From: Laura Gibbons
Sent: 06 June 2018 17:35
To: Anita Gardner
Subject: RE: R/85/18/DOC - Rustington Convalescent Home

I have reviewed the information, and provided comments in red below.

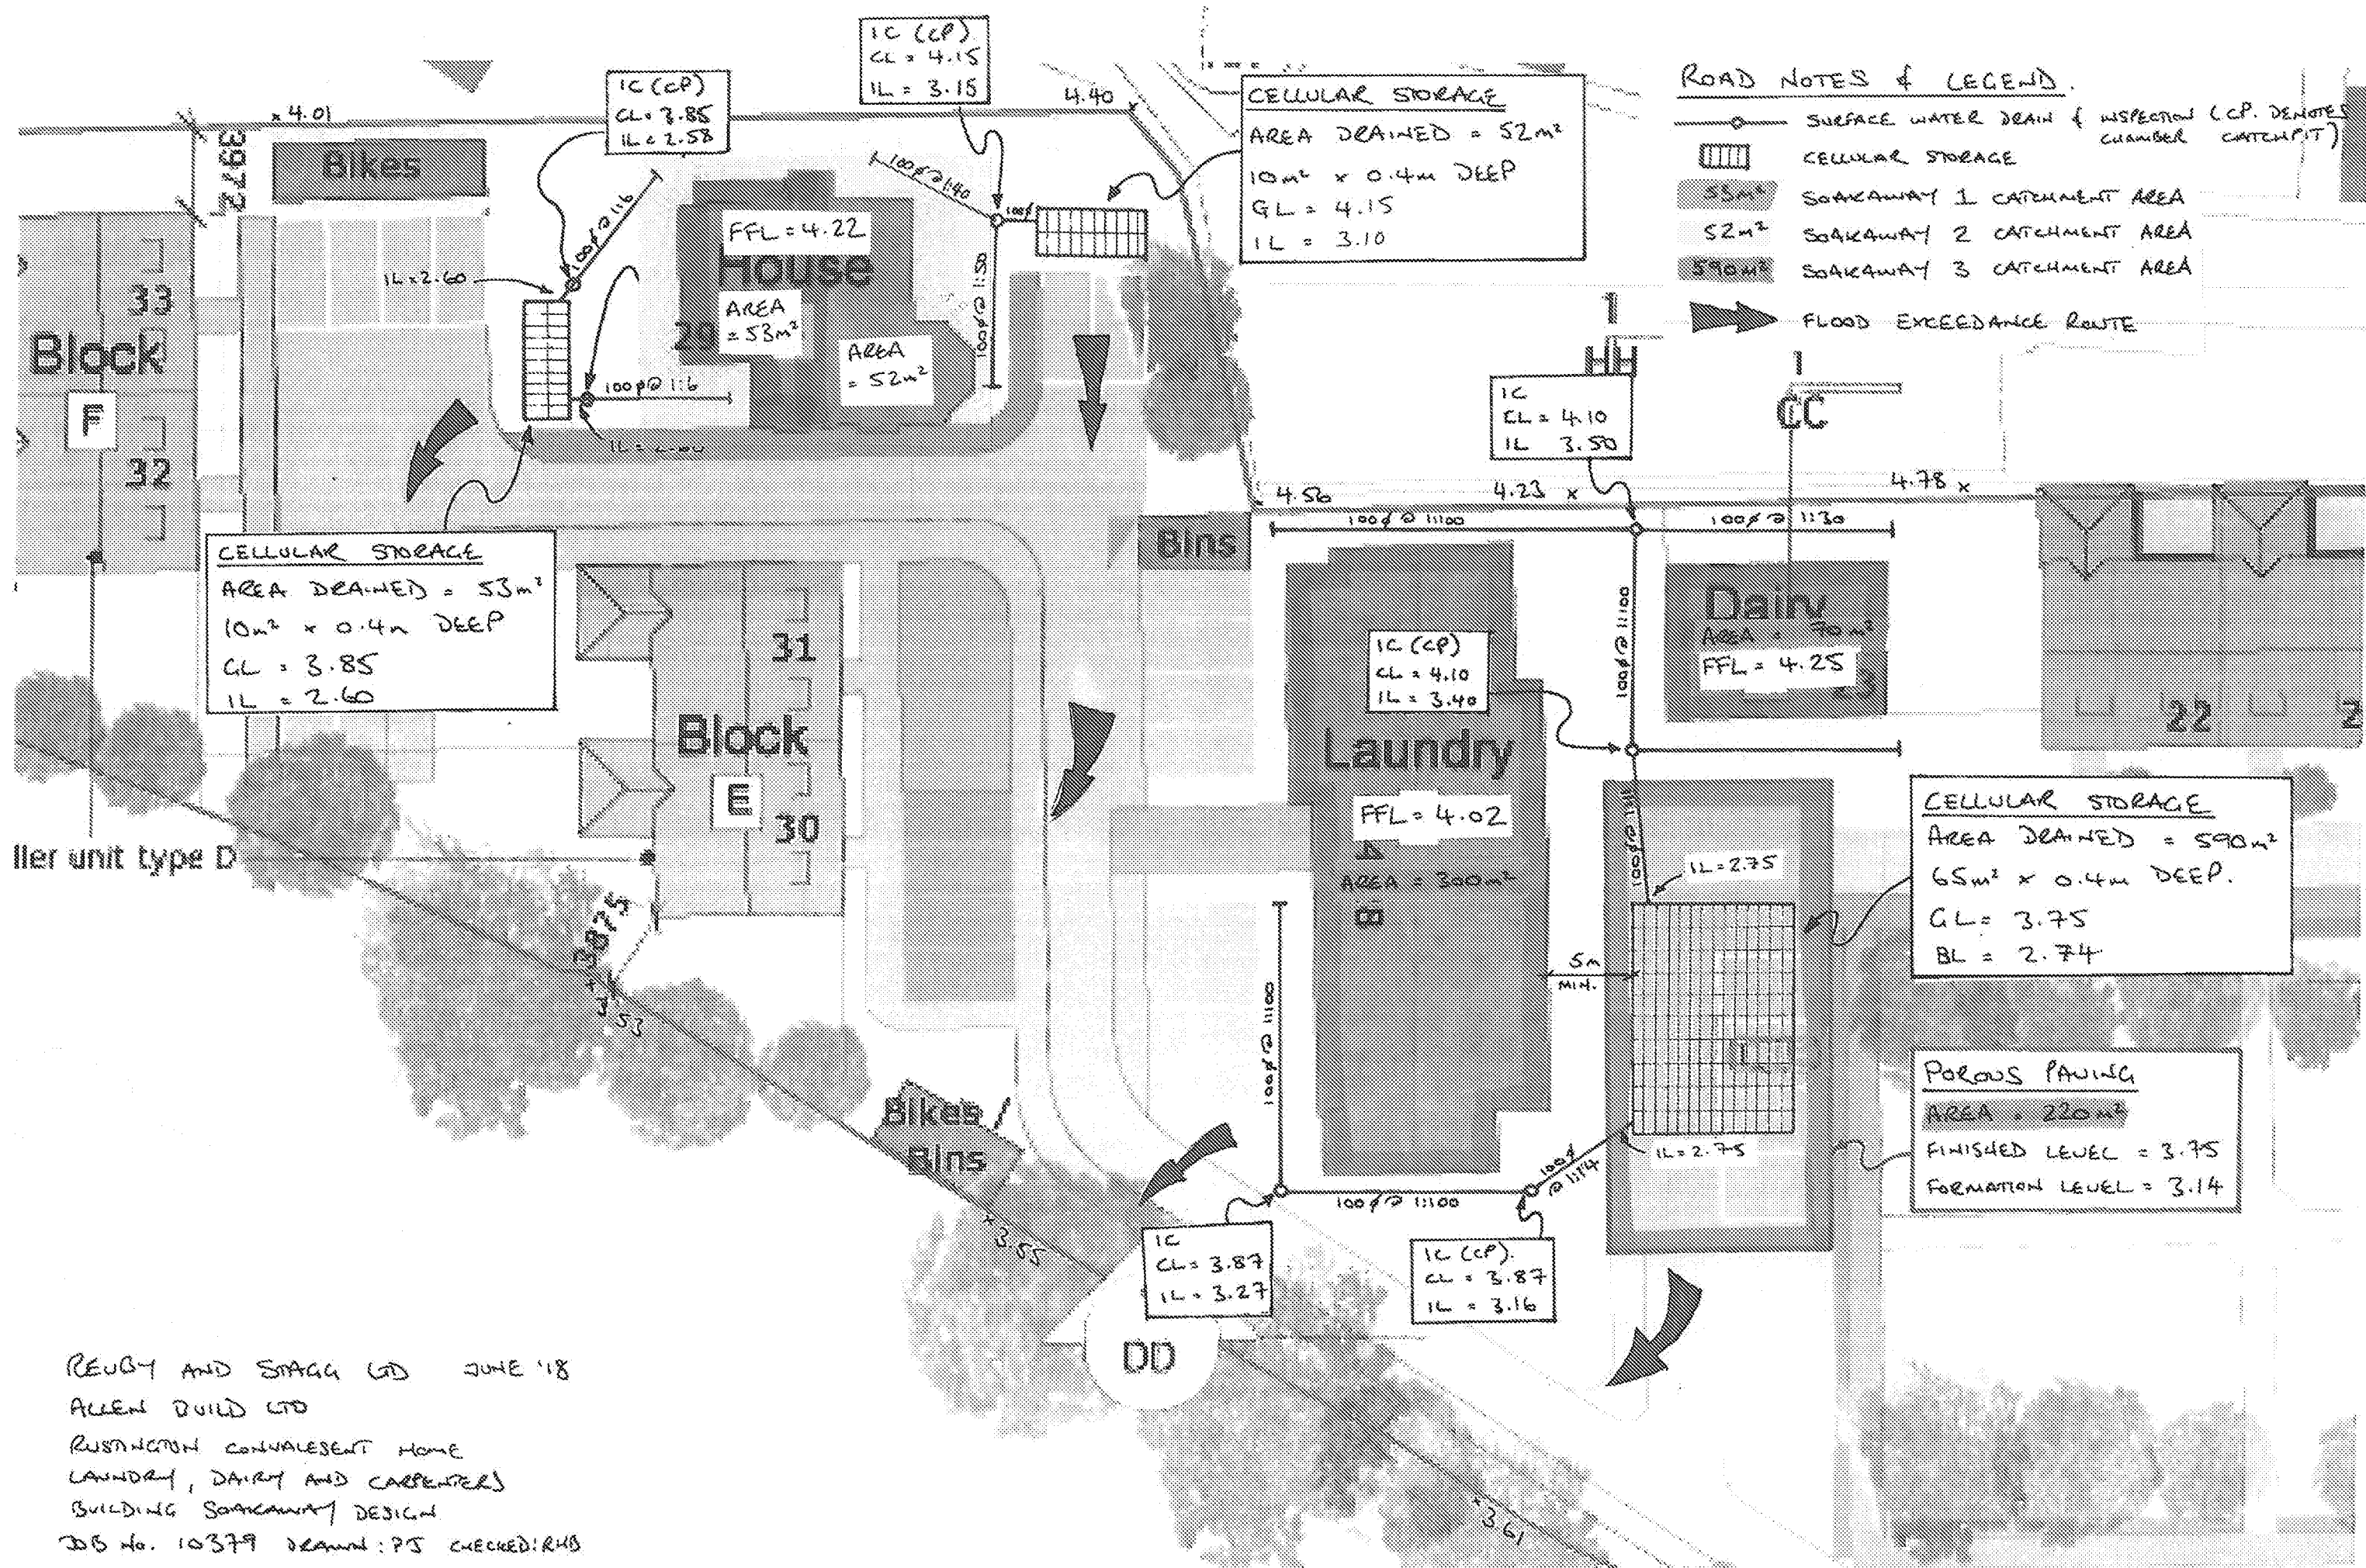
3. We will require microdrainage calculations for the proposed porous paving. Soakaway 1 needs to be increased in depth to accommodate the 1 in 100 year +40% climate change event. Modelled depths are 0.43m, the soakaway is 0.4m deep. Please revise.

PLASTIC INSPECTION CHAMBER

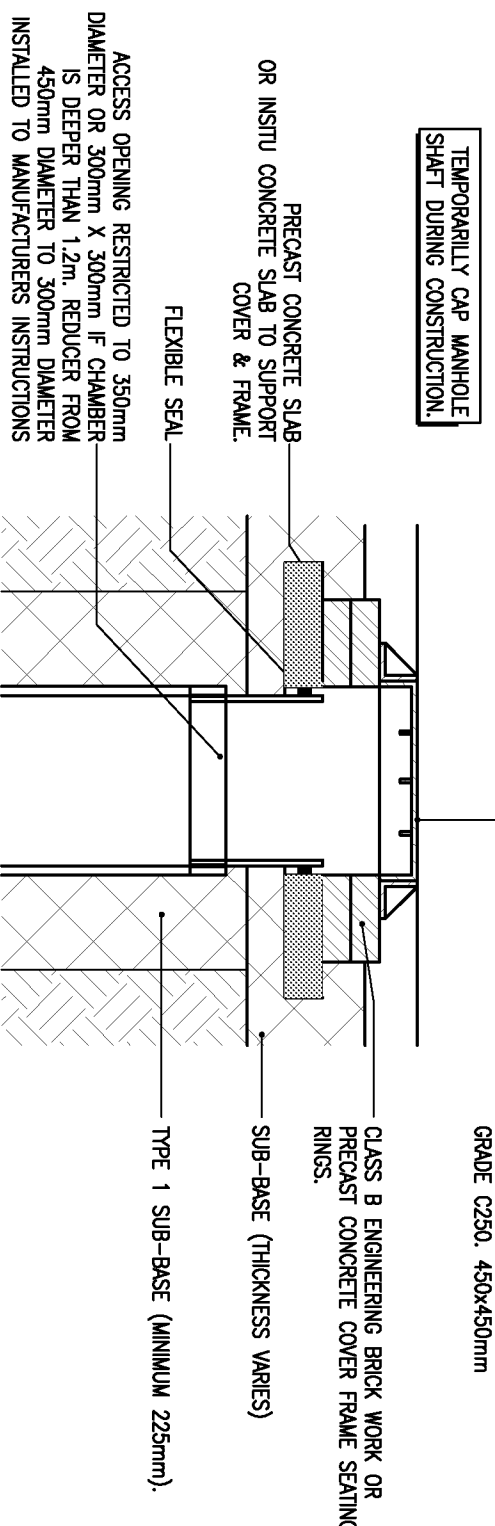
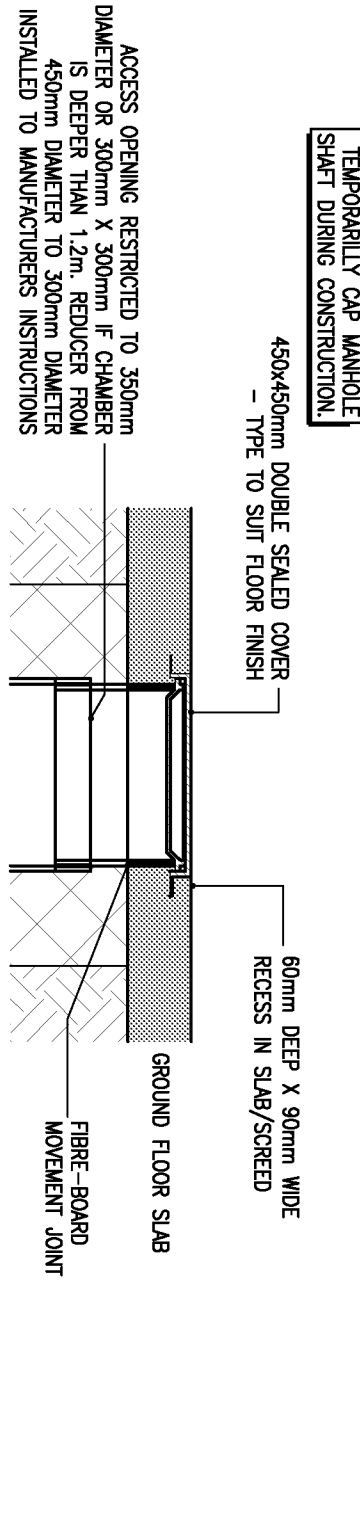
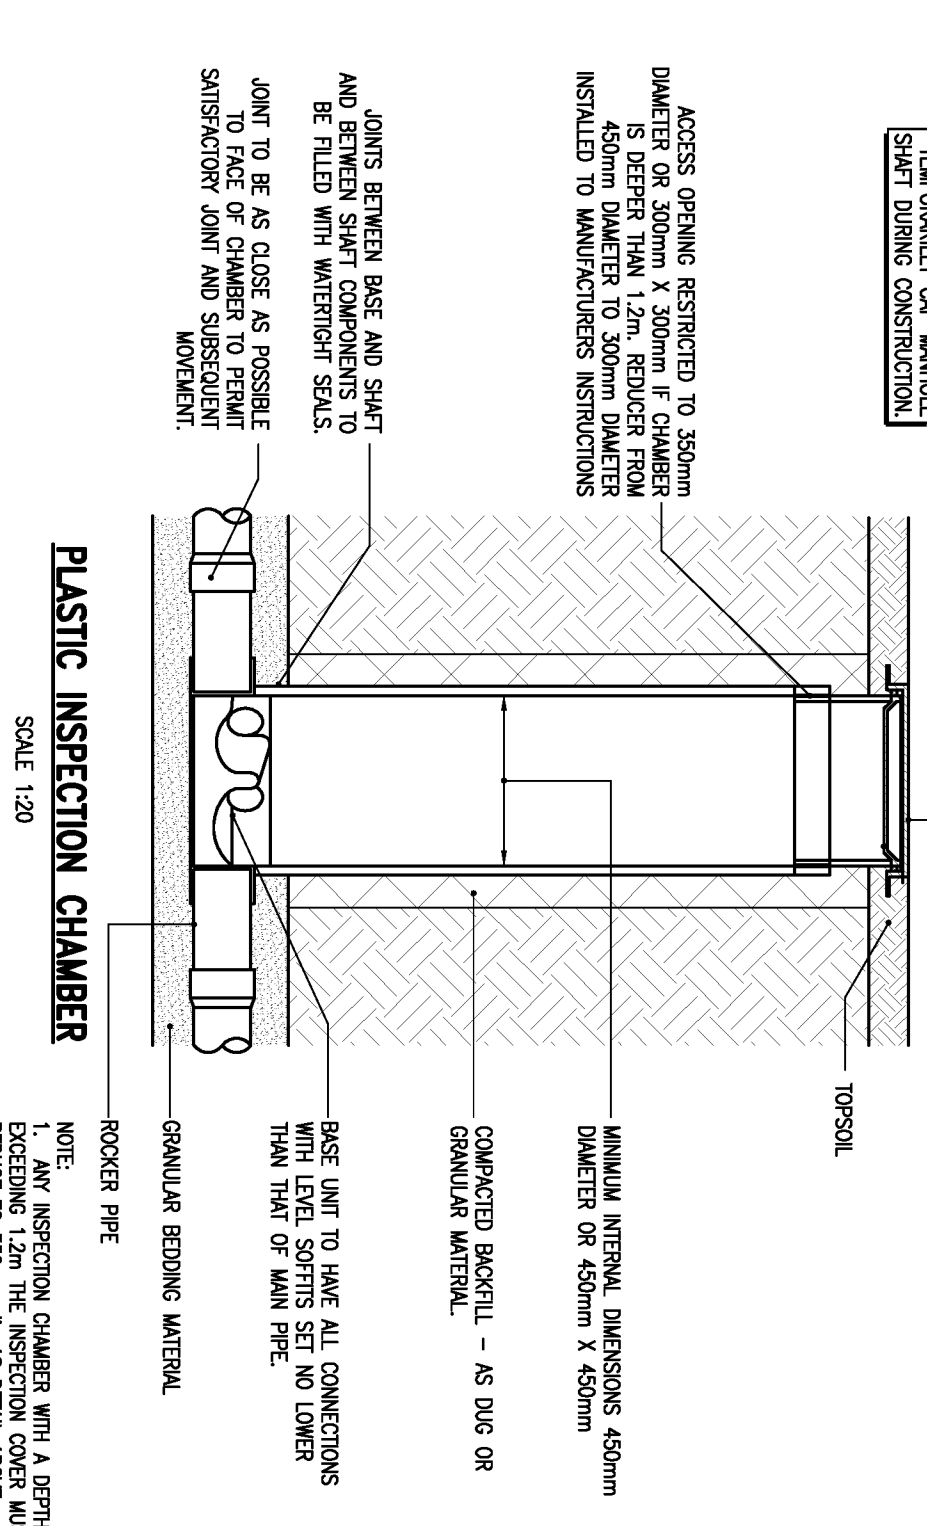
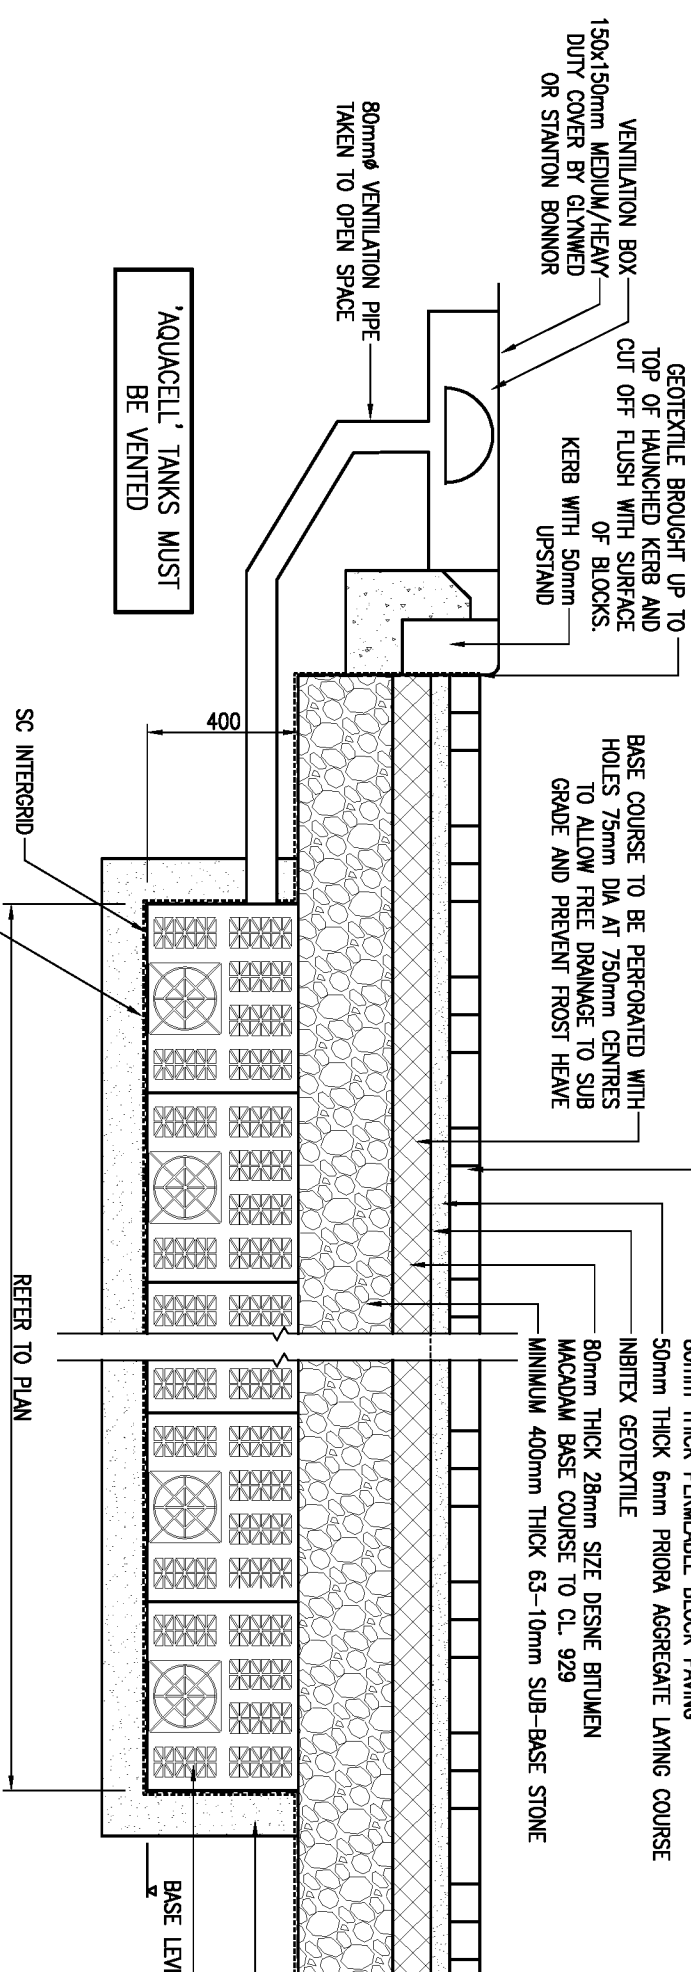
- o Pipes, labelled with invert levels, slopes and diameters. Okay.
 - o Catchpits/ manholes/ inspection chambers clearly labelled with cover types and dimensions specified. Please provide details of catchpits and cover types.

6. Construction detail drawings of all drainage structures, including; manholes, catchpits, inspection chambers, soakaways, permeable paving. Please provide catchpit details.
